Arun District Council
Arun Civic Centre
Maltravers Road
Littlehampton
West Sussex BN17 5LF
Planning & Building Control General Enquiries
Tel: (01903) 737756 Fax: (01903) 730442
Dx: 57406 Littlehampton
Minicom: 01903 732765
e-mail: planning@arun.gov.uk
website: www.arun.gov.uk/planning

Application No: FP/212/20/OUT
Site Address: Pipers Croft 6 The Loop Felpham PO22 7ND
Description of works: Outline application with all matters reserved for 1 No. 4 bed detached dwelling.

Thank you for your internet representation made on 30th November 2020 which has been recorded as an objection with the comments as follows:

Title
Block and Location Plans

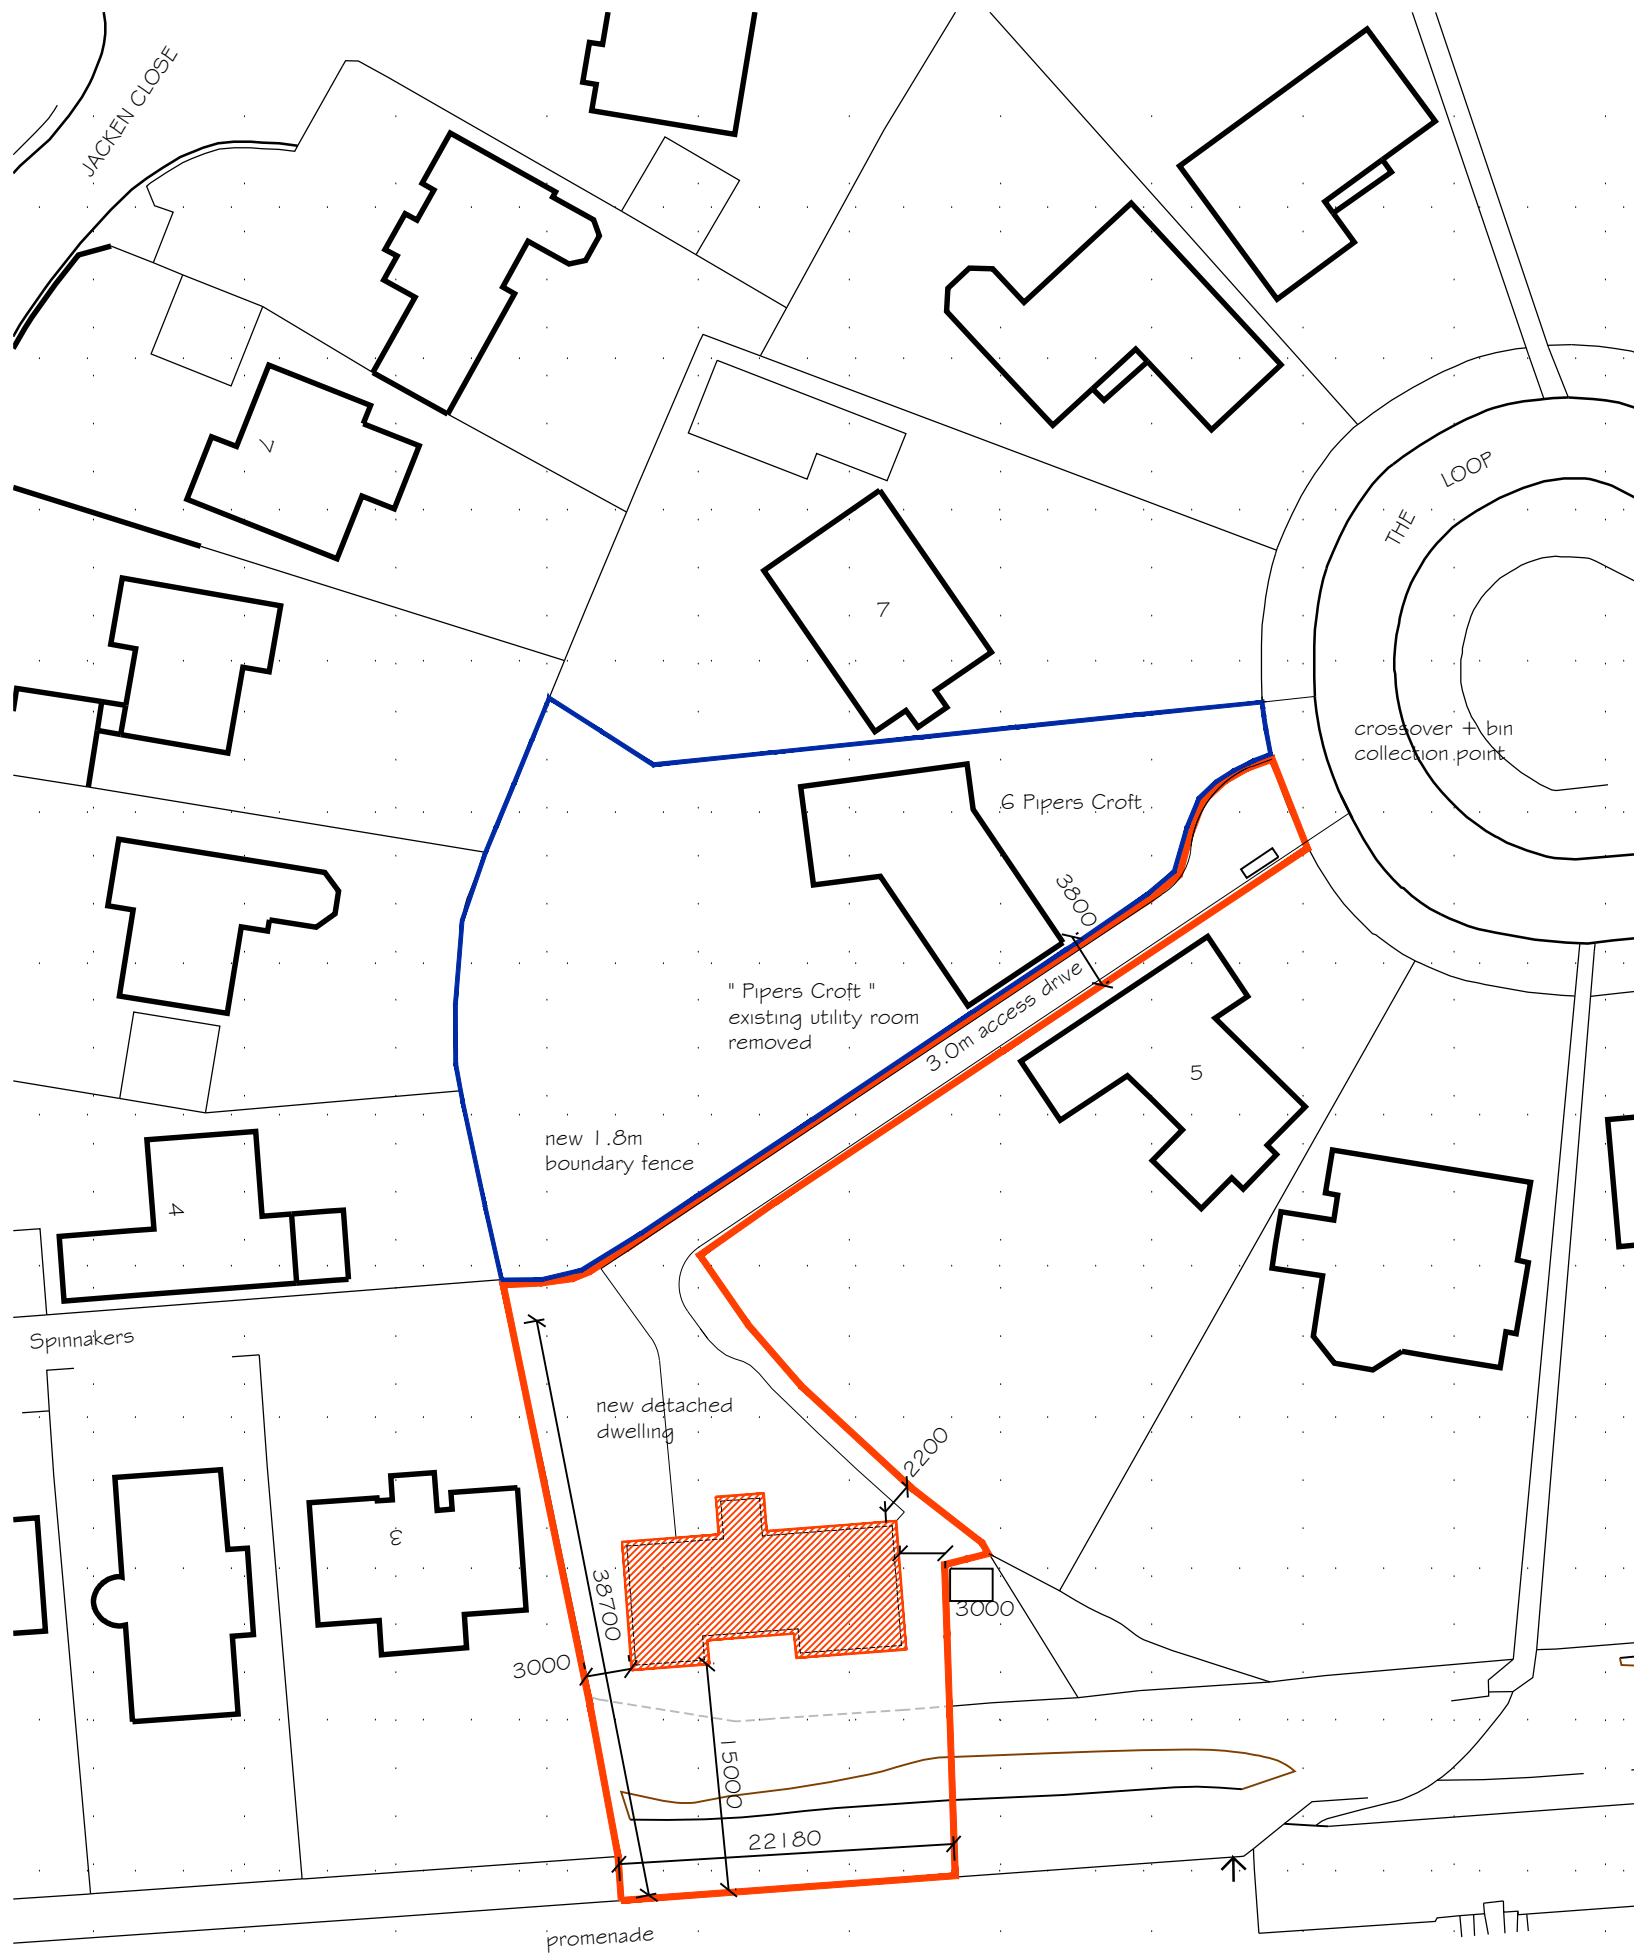
This land is key to drainage for properties on the Summerly Estate. It is not clear from the plans presented how the drainage system will be preserved to protect current residents and their properties. There is also an issue of parking as parking on the roads and verges is not permitted on the Summerly Estate.
